MARTIN PLACE STATION MODIFICATION SUBMISSIONS REPORT

The NSW Government has received an unsolicited proposal from Macquarie Group Limited (Macquarie) for a single fully integrated station and over station development solution for the approved metro station at Martin Place. The proposal would provide a larger, more connected station and precinct to serve Martin Place and provide a better opportunity to provide a whole of precinct urban design response.

During public exhibition of the modification report, 11 submissions were received by the Department of Planning and Environment. The Secretary of Department of Planning and Environment provided copies of the submissions to Transport for NSW. This report provides responses to the issues raised in submissions.

**Figure 3 – Sydney Metro Martin Place Station – proposed modification layout**  
(Source: Martin Place Station Modification Submissions Report, Transport for NSW, 2017)

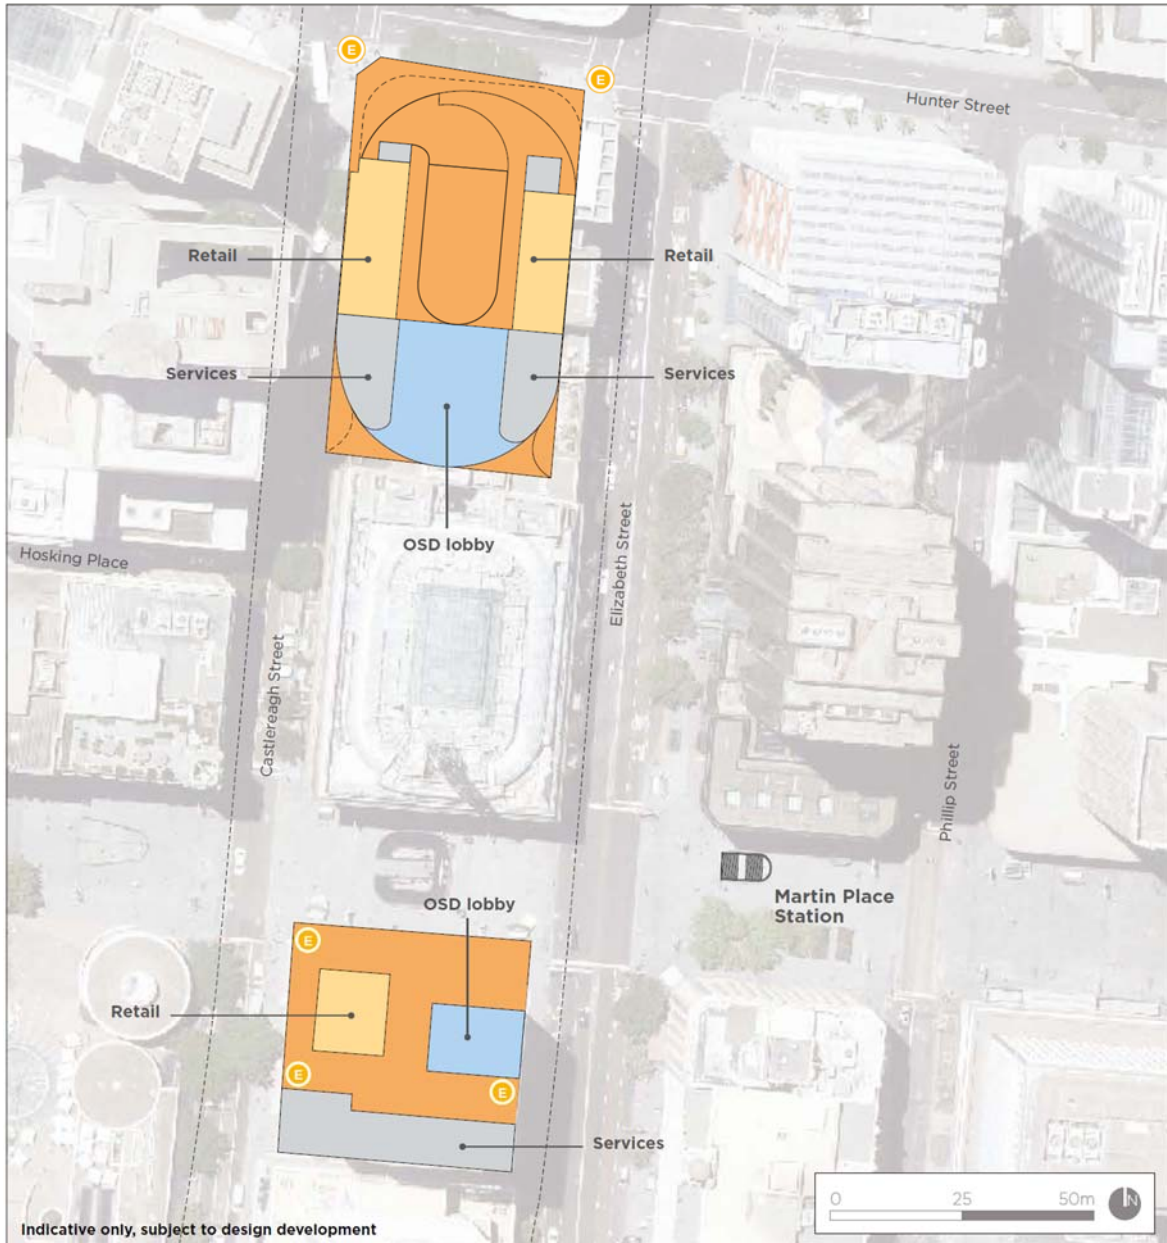
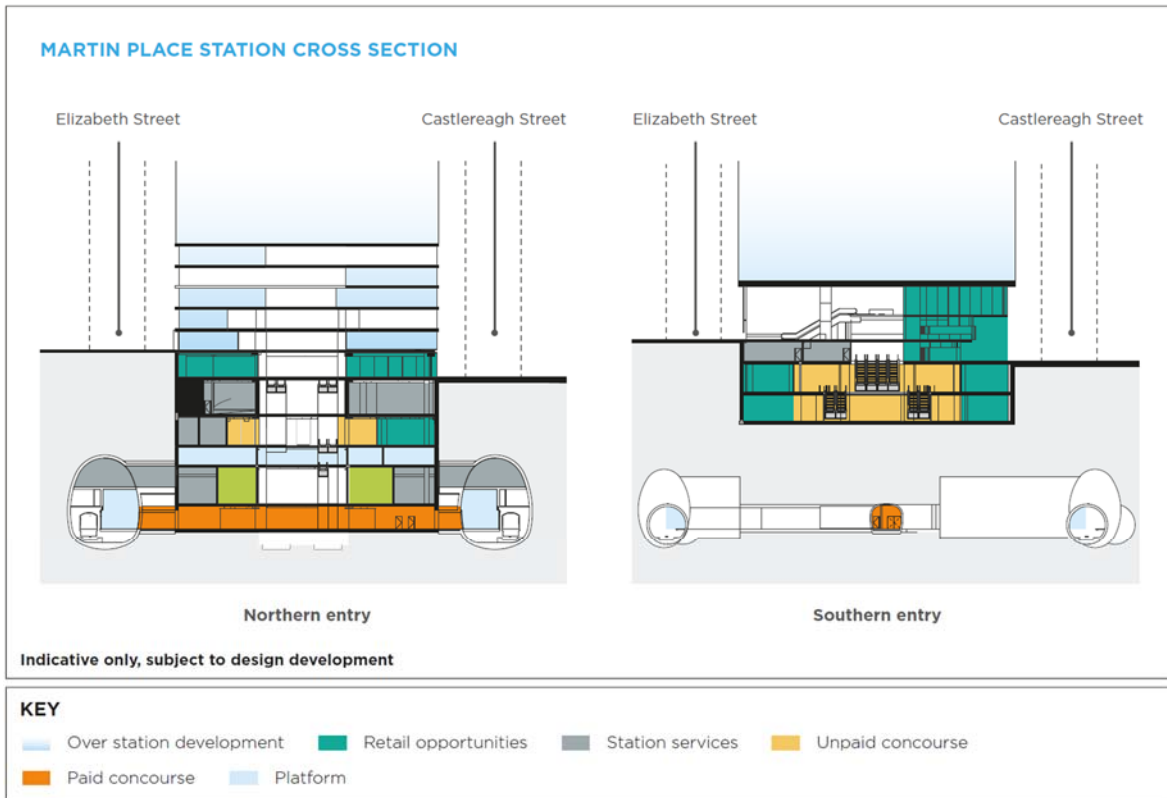
The plans for the proposed station entries are inconsistent with the cross-sections provided and are misleading. The plans show that the whole site area will be occupied by a pedestrian plaza / station lobby, with some service and operational area. This is not the case because, as shown by the cross-sections, it is clearly intended that some of this space will be occupied by over station development entries and retail, particularly in the northern station. Due to the inaccuracy of the plans, it is not possible to determine if the station area is larger than the approved works, but it appears that it is not.

Issues raised in relation to the design of the southern entry include:

- The entry arrangement has been modified. The modification will encourage pedestrians to cross Castlereagh Street outside the signalised box
- Entries should be located at the corners closest to signalised crossings. This will provide the most direct access from the signalised intersection into the station. It will also prevent the need to extend the signalised crossing along Castlereagh and Elizabeth streets

- There should be active frontages to Martin Place. Preferably the commercial lobby entry would be located on Martin Place, and the level change managed internally

- It is noted that the direct lift access has disappeared from the sections for the southern entry. This must be provided in both station entries to facilitate equal access requirements

- A ground level setback to Martin Place is not supported. A colonnade to Martin Place is not supported. The station must contribute to definition of the street wall along Martin Place.

The plan view of the station entries provided in the modification report shows a general station plaza / station lobby area as part of the conceptual station design. The submission from City of Sydney correctly identifies that some of this space would be used for retail purposes and entries to the over station development. This is due to the proposed modification representing a more integrated solution than the approved project.

As identified in Section 6.3 of the modification report, the proposed modification would provide an increase in public plaza space at both entries when compared to the approved project.

The proposed modified design of the southern entry and the interface of the plaza space with Castlereagh Street is substantially similar to the design presented in the Environmental Impact Statement. At this location, the approved project and the proposed modification both involve a station entry plaza which opens onto both Martin Place and Castlereagh Street, The proposed modification would not result in more pedestrians being encouraged to cross Castlereagh Street outside the signalised crossing when compared with the approved project. Integration with surrounding precincts and pedestrian facilities would be further developed as part of the Interchange Access Plans required under Condition E92 and the Station Design and Precinct Plans required under Condition E101.

Direct lift access is proposed at both Martin Place Station entries.

A ground level setback to Martin Place is not proposed in the design. The basis of the design and the design principles are outlined in the State Significant Development Environmental Impact Statement for the over station development. That document provides some indicative artists' impressions of how these design principles could be achieved. In relation to the interface of the southern site with Martin Place, the relevant principles which would continue to be considered during the development of the design are:
